**Re: Design Submission for Old Bray Road, Cornelscourt, Dublin 18, Co. Dublin (the “Development”)  
(the “Design Submission”) / Connection Reference No: CDS20003703**

We have reviewed your proposal for the connection(s) at the Development. Based on the information provided, which included the documents outlined in Appendix A to this letter, Irish Water has no objection to your proposals.

### Appendix A

DRG. TITLE  
**IRISH WATER INTERCEPTOR SEWER LONG SECTIONS**

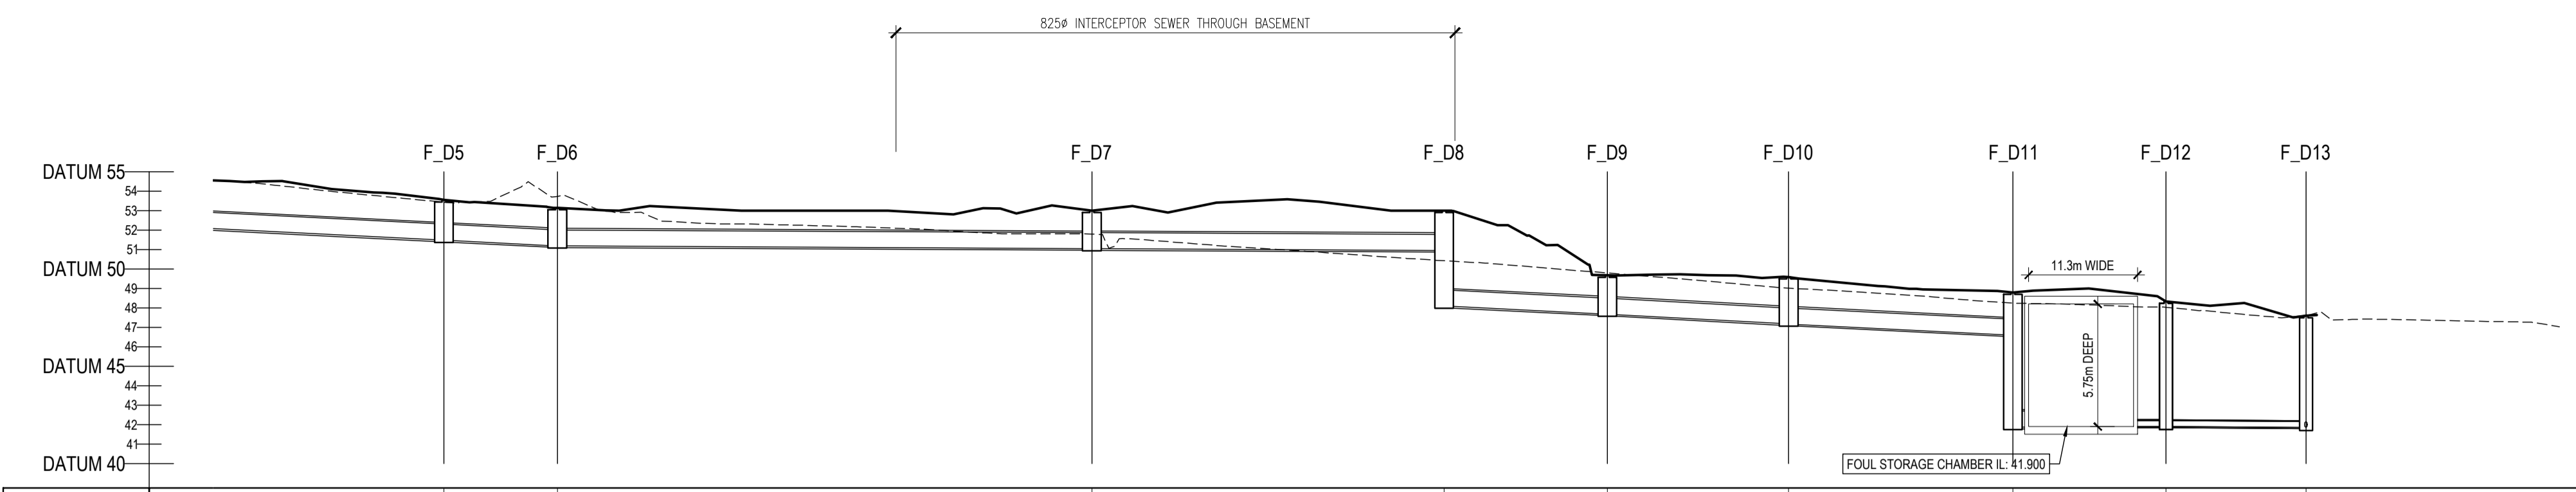
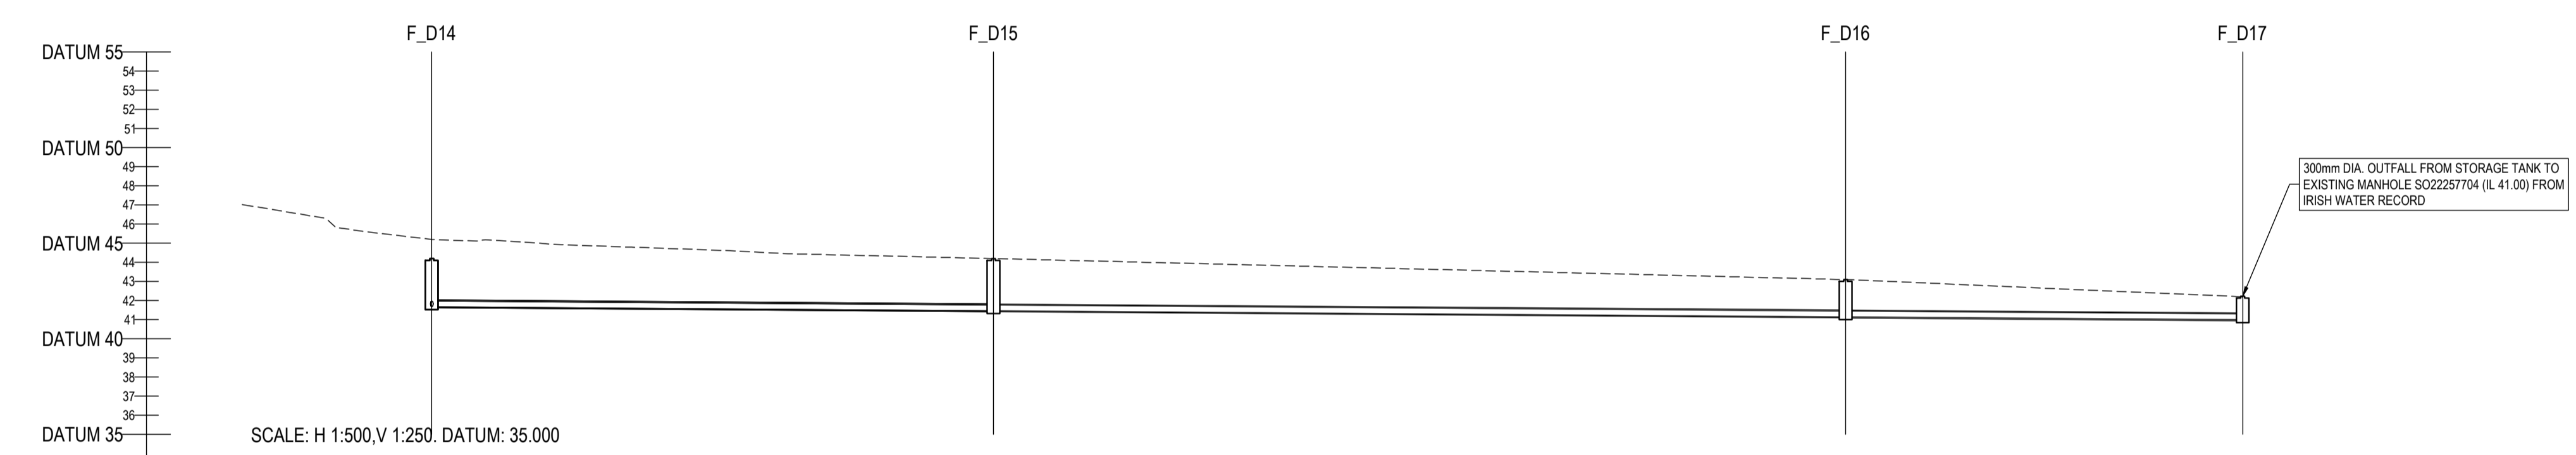
**This Statement of Design Acceptance does not extend to the proposed 825mm diameter interceptor pipe.**
